Consultation Response from: KC Environmental Health (Pollution & Noise Control)
2026/91969 land off, Fenay Lane, Almondbury, Huddersfield, HD5 8UJ
Erection of 6 dwellings, with associated access, landscaping, infrastructure and works
Date Responded:
13/08/2026

Responding Ref:
WK/202623848

1002 B EHS TREE PLANTING IN SOFT LANDSCAPE 1:25

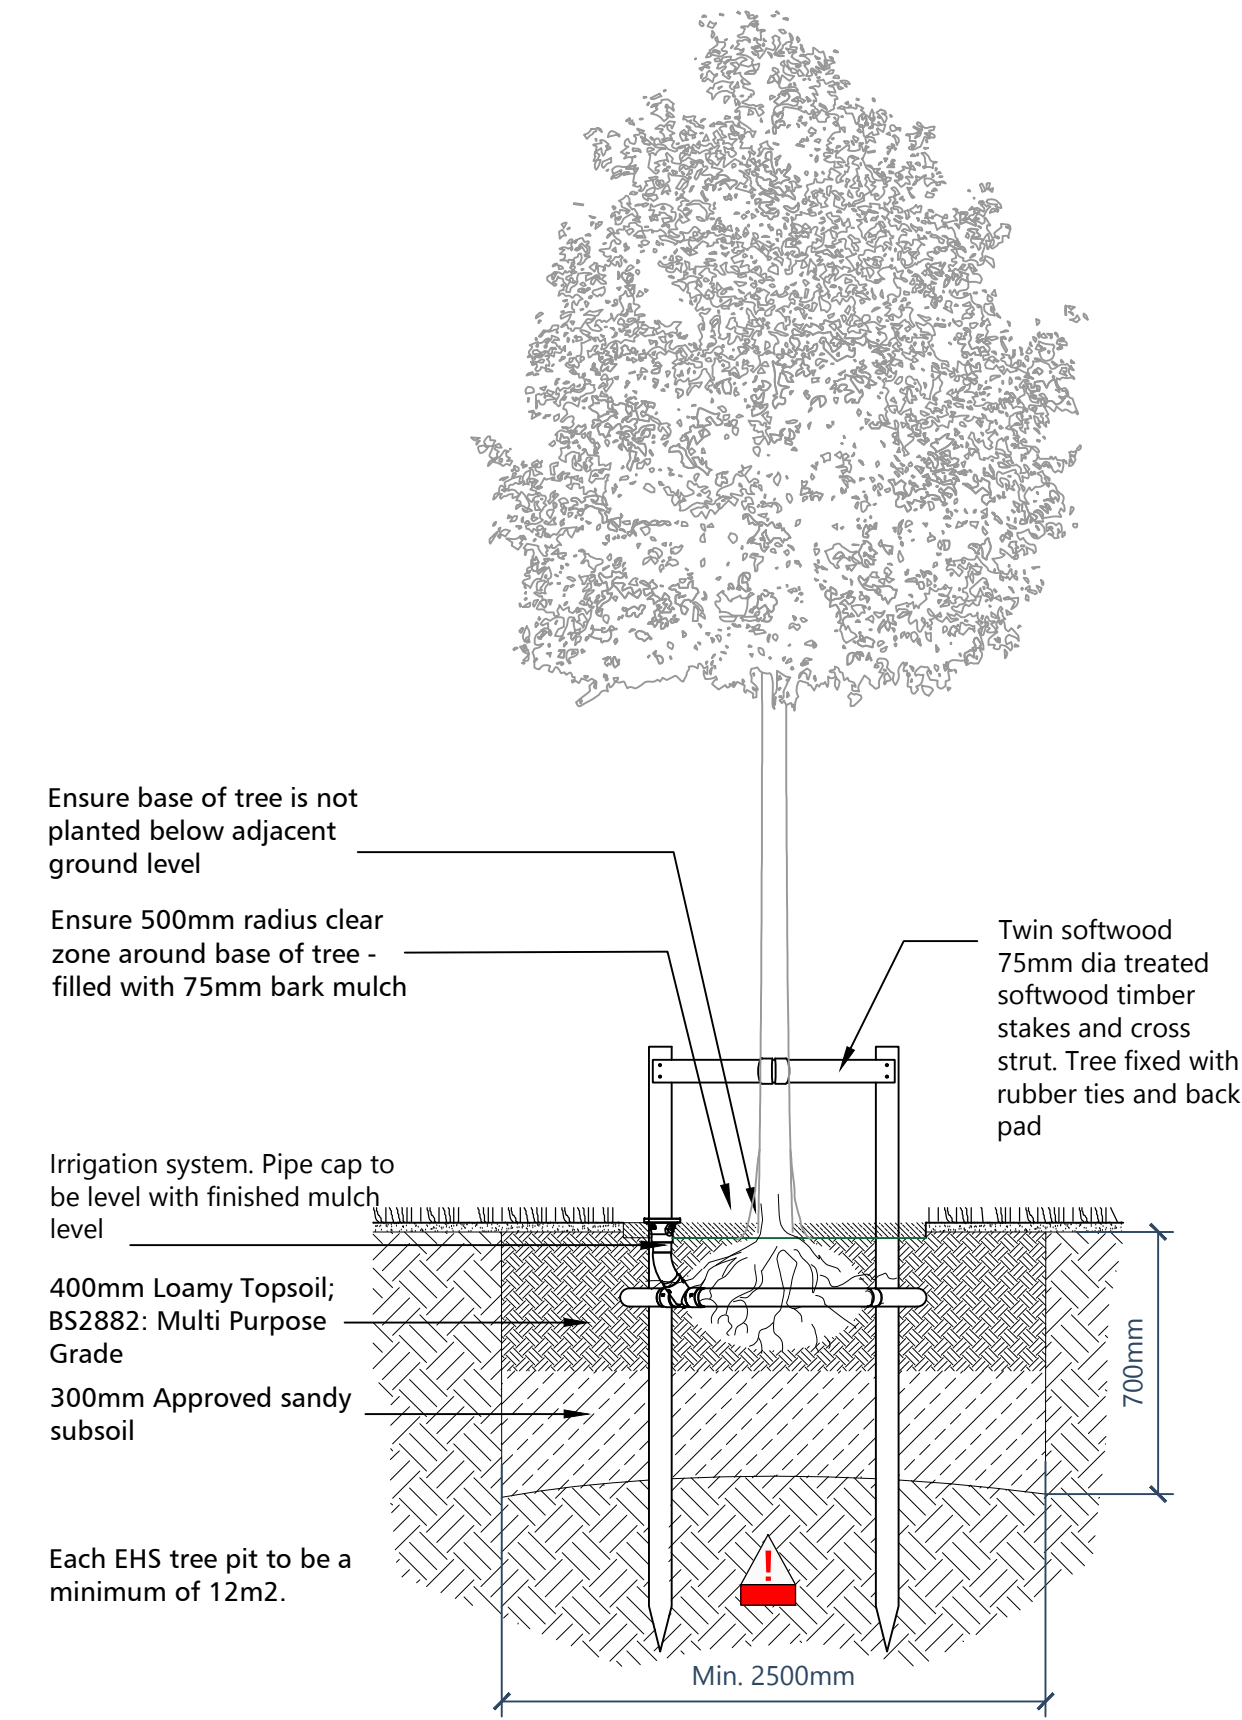
We also note that Drawing 1002 '*Landscape Specification*' suggests that imported topsoil is anticipated as part of the approved scheme. The applicant must ensure that the material is suitable for the intended use and that the material does not contain unacceptable levels of contamination. Therefore, we need further information as to how this will be achieved. A condition on imported material is therefore required.

Prior to materials being imported to the site, a strategy detailing the intended placement, the source, characterisation and the suitability of any imported material must be submitted to and approved in writing the Local Planning Authority. The testing to demonstrate suitability must then be carried out in accordance with the approved strategy. Following importation and placement of the materials as described in the approved strategy, a Verification Report shall be submitted to the Local Planning Authority. No part of the site shall be brought into use until such time until a Verification Report has been approved in writing by the Local Planning Authority.
